re: **Response to City Comments**
 Proposed Residential Development
 475 Terry Fox Drive – Ottawa, Ontario

date: July 14, 2026

file: PG7418-MEMO.01 Revision 4

scale 1:400	drawn by TF	designed by VO
date 2025-01-02	checked by MR	plot date
project number 25-1761	drawing number L - 01

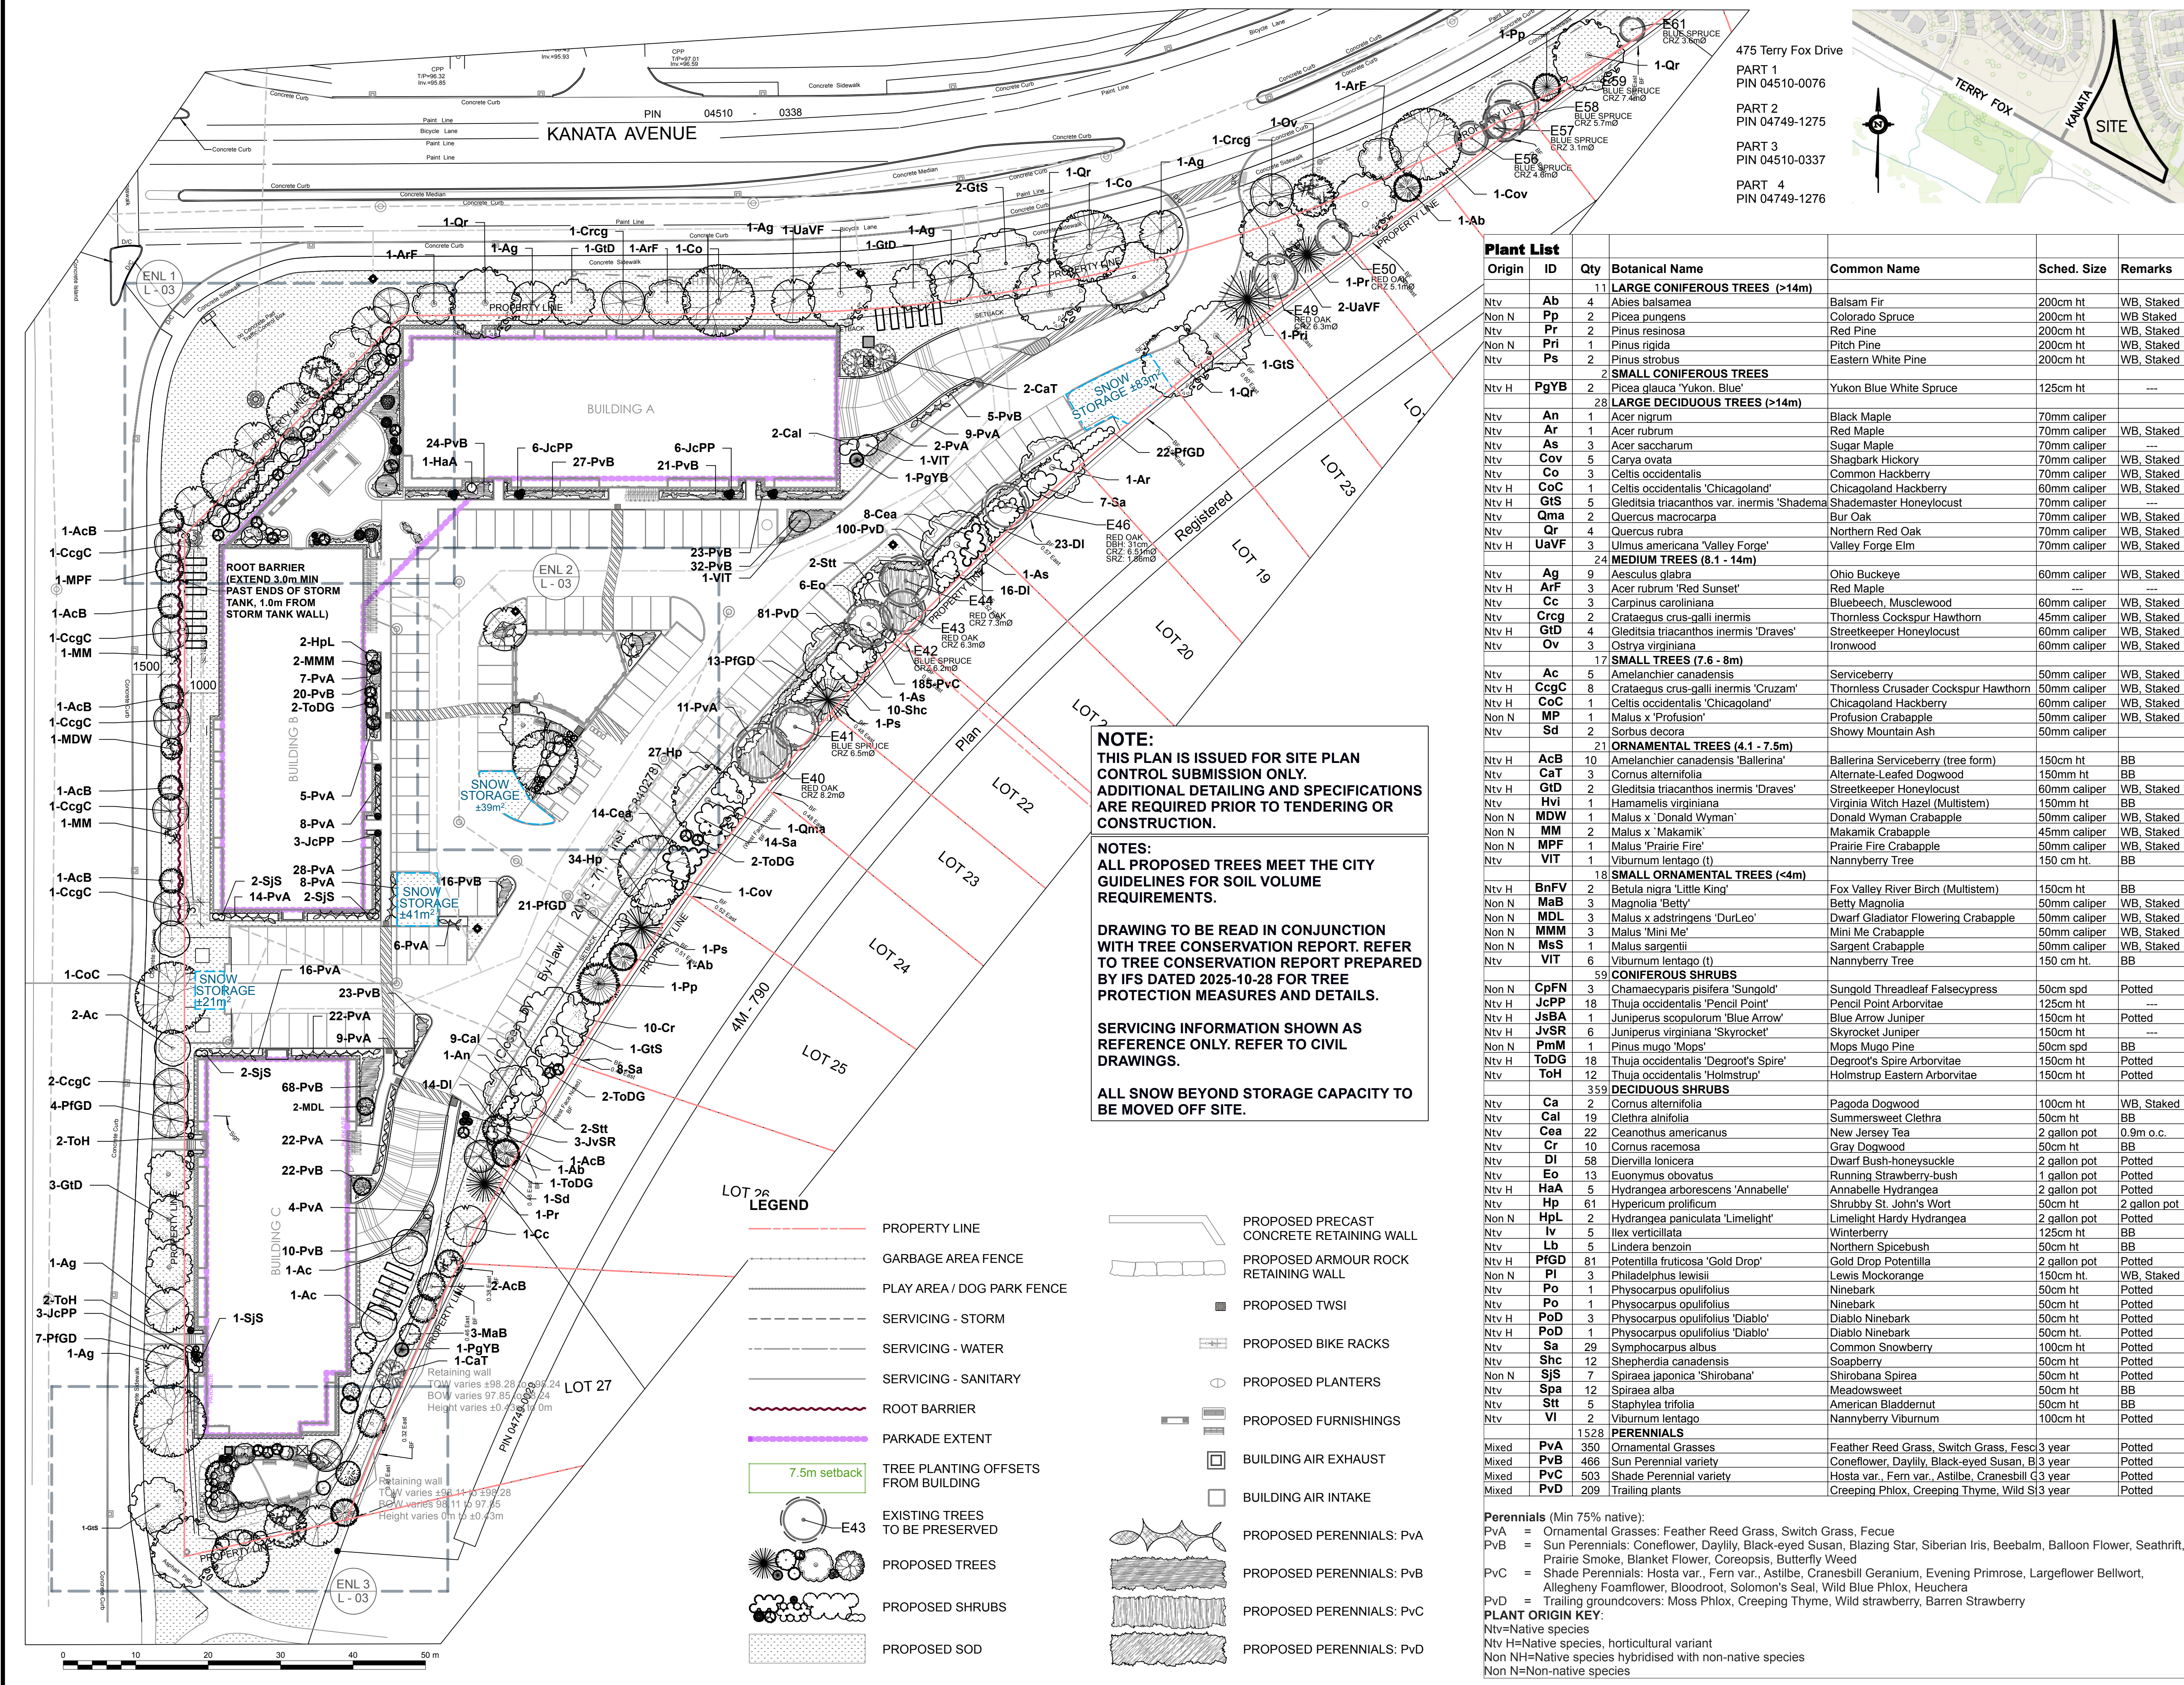
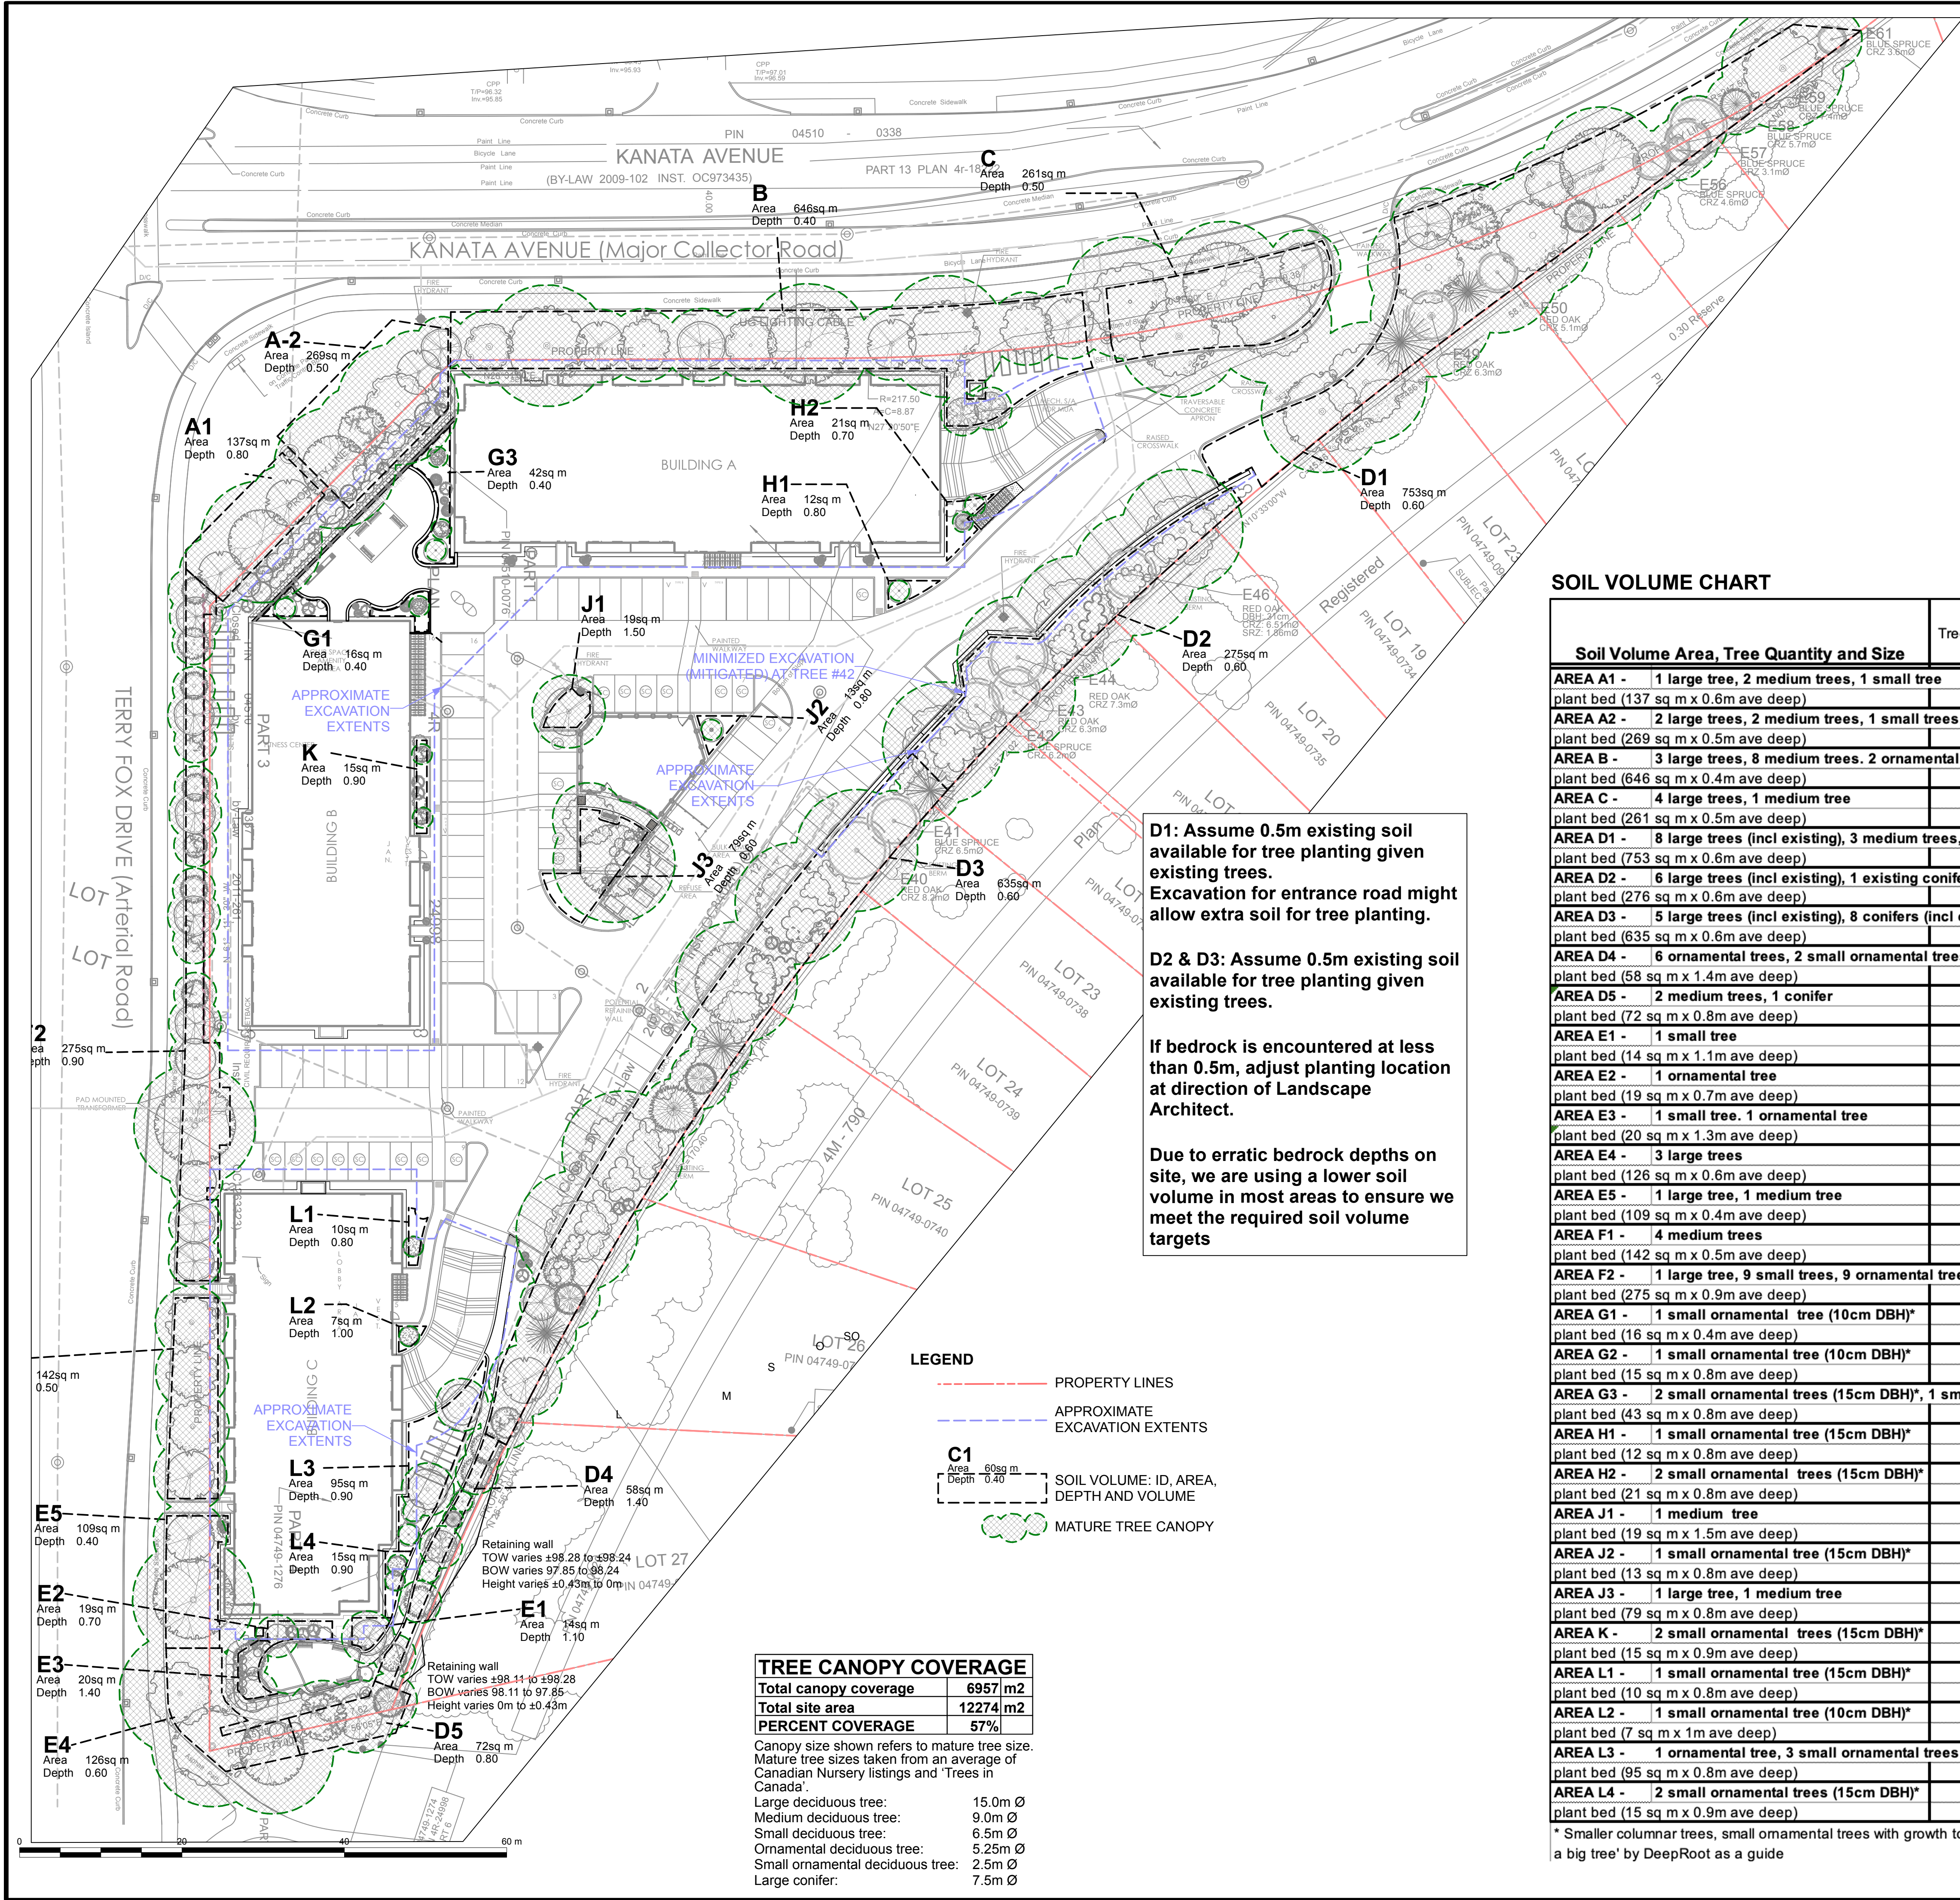
Comment 56: *Do planting restrictions apply to trees of size smaller than 7.5m in height? Note that some small coniferous trees and ornamental trees (4-1m – 7.5m and < 4.0m in height) are being proposed within 4.5m from the foundation.*

Comment 27a: *The geotechnical investigation and geotechnical responses to City comments, both prepared by Paterson Group, contain conflicting information with regard to landscaping considerations. The investigation recommends tree planting setbacks in accordance with SMC planting guidelines, but the response document describes deep foundations (not supported on clay), removing the need for tree planting setbacks. Please clarify the recommendations within the geotechnical report, based on the foundation type and depth. If no SMD setbacks apply, the Landscape Plan must be revised with larger-growing trees in the ROW.*

Response: At this time, it is understood that the proposed structures will be supported by deep foundations consisting of driven piles extending to refusal to advancement. Since the structures will be supported by a foundation that does not attain support from the clay subsoils, there are no applicable tree planting setback restrictions for the proposed structures from a geotechnical perspective.

Response: Paterson understands that the proposed foundations will consist of deep foundations such as end-bearing driven piles or conventional spread footings placed on the bedrock surface. Since the proposed buildings will not be supported by the clay deposit, there are no applicable tree planting setbacks for the building footprint, which have been removed from the current Geotechnical Report.
